From: Justin Meleo [jmeleo@orogen.com.au]
Sent: Monday, 22 September 2008 11:23 AM
To: 'fergus.hancock@dnr.nsw.gov.au'
Cc: Mark Daniels (markdaniels@buildev.com.au); 'colin.phillips@planning.nsw.gov.au'; Tony Fish (tfish@orogen.com.au)
Subject: DWE comments - Fullerton Cove Sand Extraction MP 07_0145

Subject: Additional assessment – Buldev Properties MP 07_0145

Re: Fullerton Cove Sand Extraction – Major Project 07_0145

EXISTING LANDFORM AND PROPOSED EXTRACTION PLAN

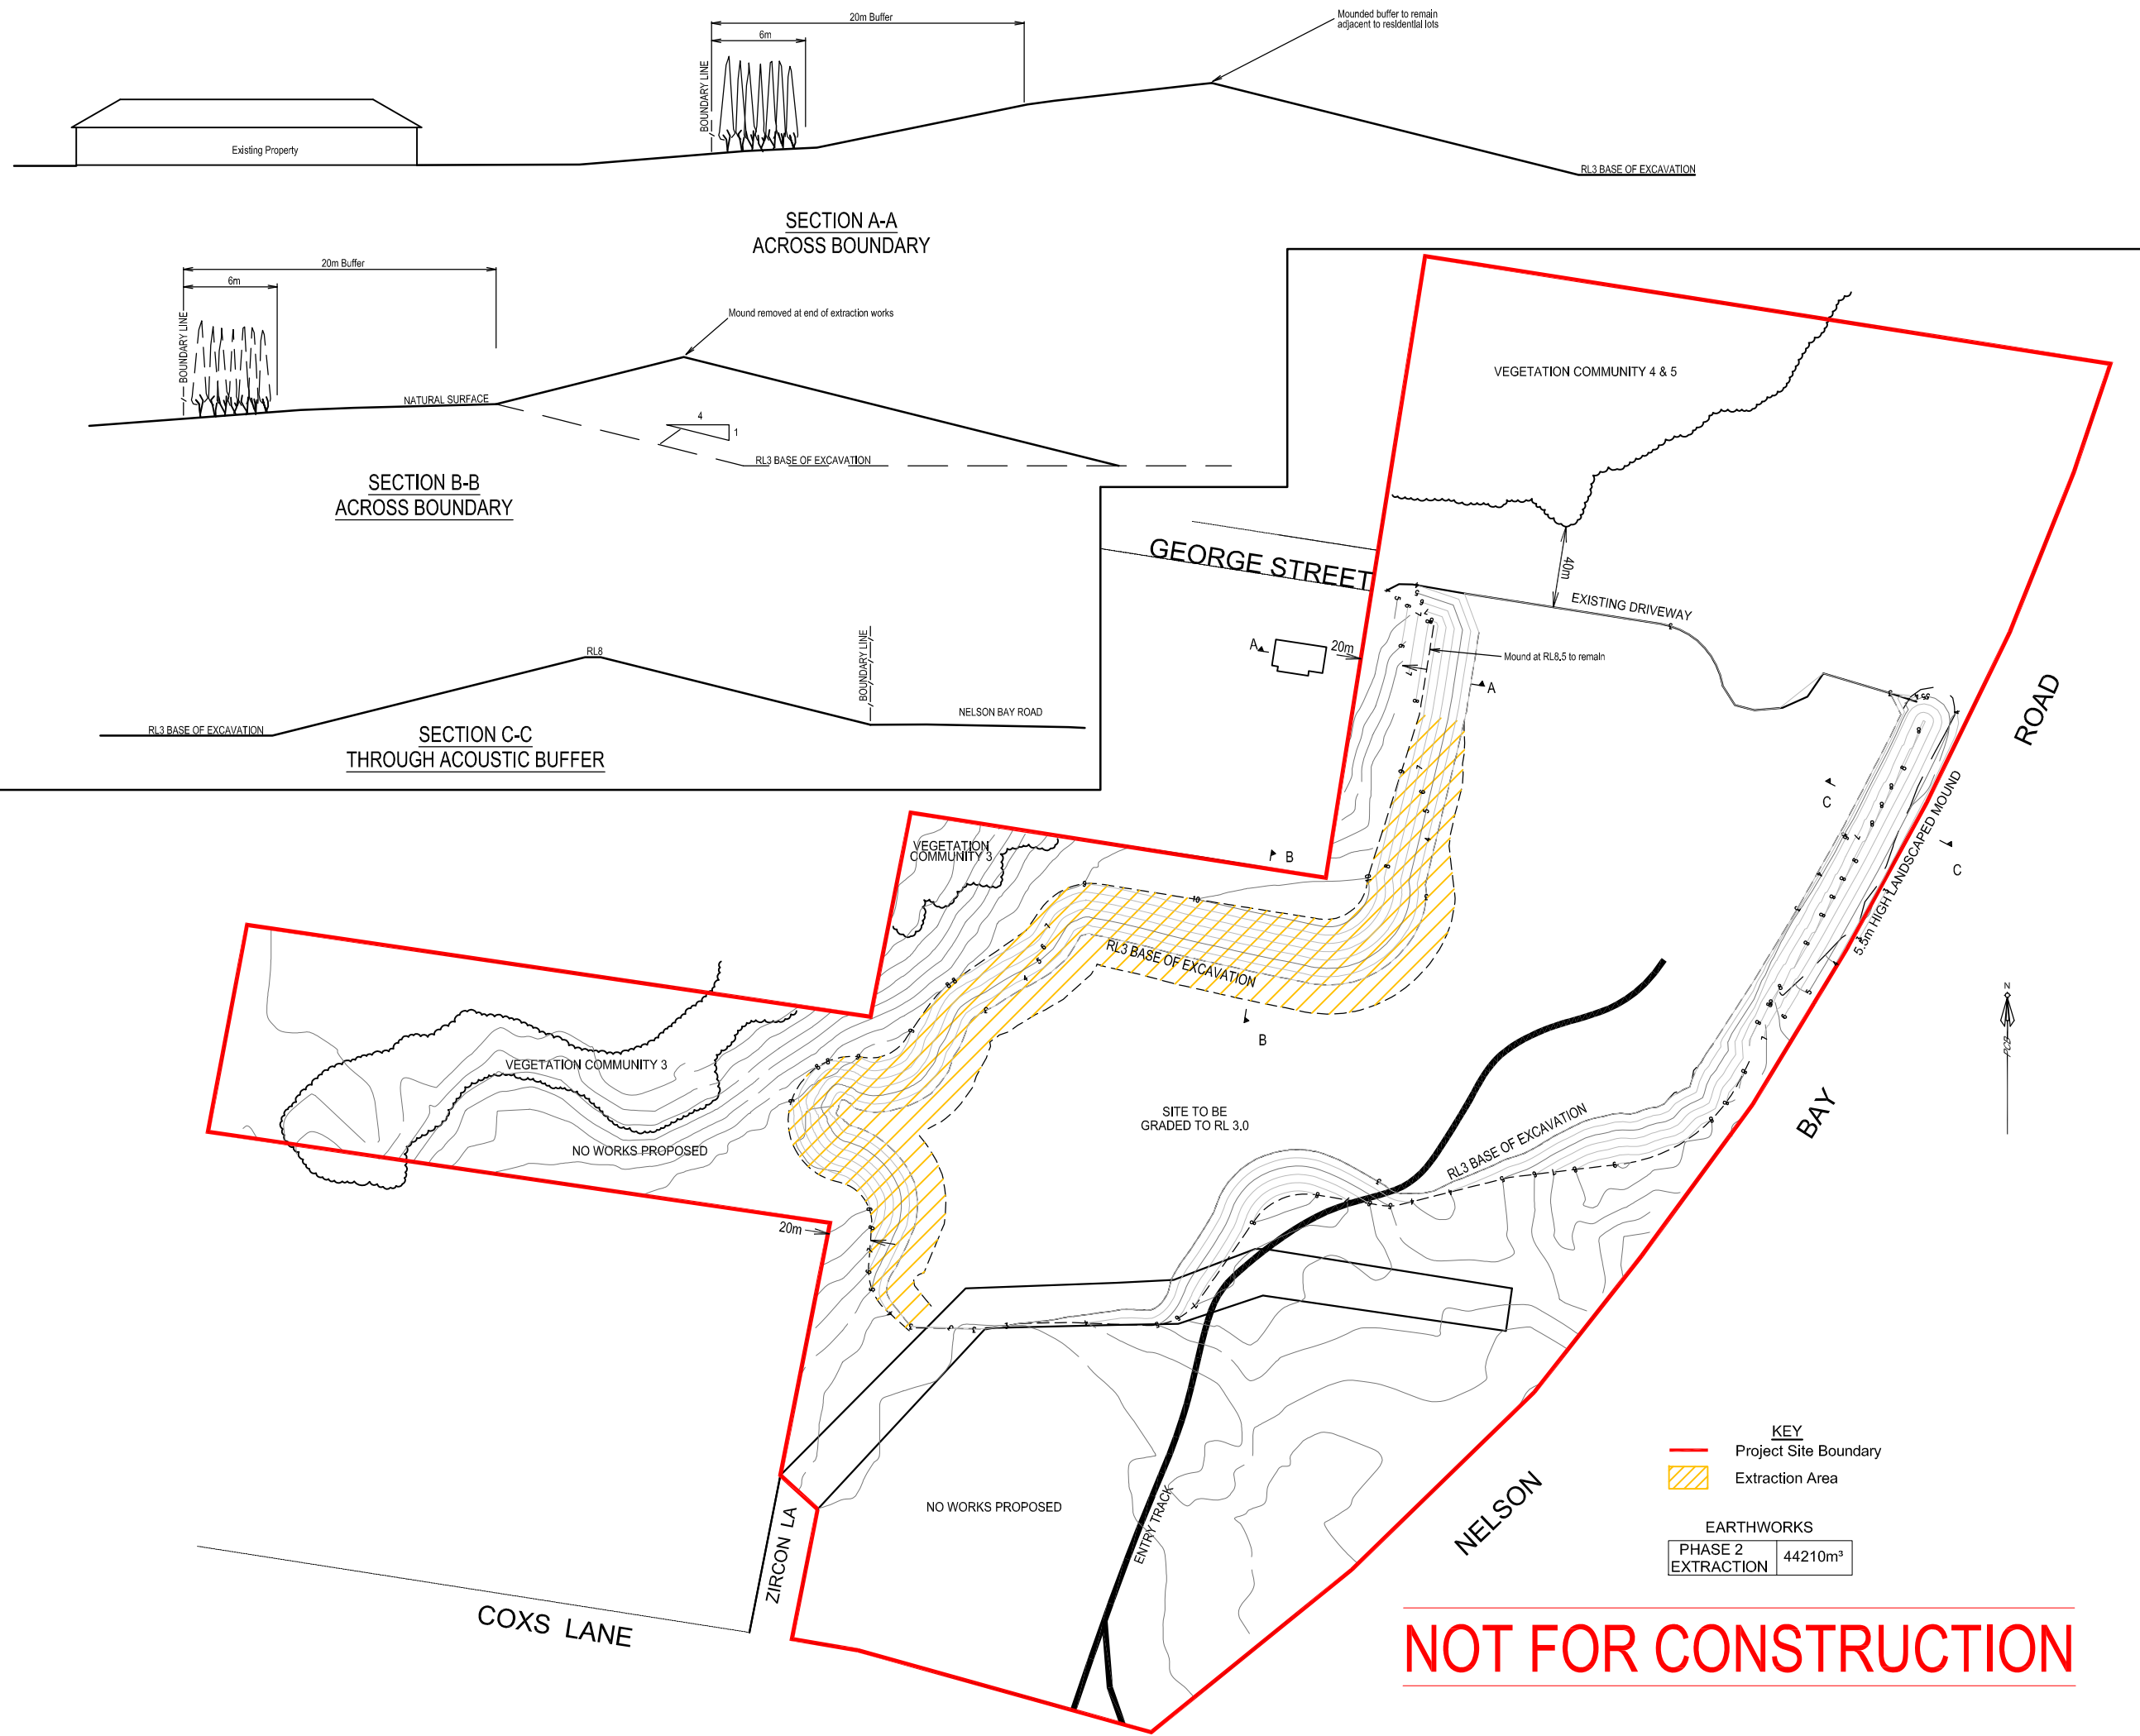
The Department of Water and Energy (DWE) has reviewed the proposed additional modelling and proposed purchase of entitlement from the Stockton Groundwater source. The modelling work must provide confirmation that extraction will not intrude into the 1 metre buffer nominated in the Environmental Assessment; depth of extraction must be limited to the minimum 1 metre buffer.

DWE considers establishing the limits of extraction to 1 metre above maximum predicted groundwater table of critical importance to the project approval, and therefore the final landform which may be defined for the project approval must be established in compliance with DWE requirements and technical assessment prior to project approval being granted. The other issues raised in your communication may be addressed as management requirements subsidiary to the project approval.

Further, the DWE's attention is drawn to an amendment to the proposed extraction area, which now excludes that part of the site north of the George St entrance. This means that the extraction area will be a minimum of 40 m from the GDE's identified as Vegetation Communities 4 and 5.
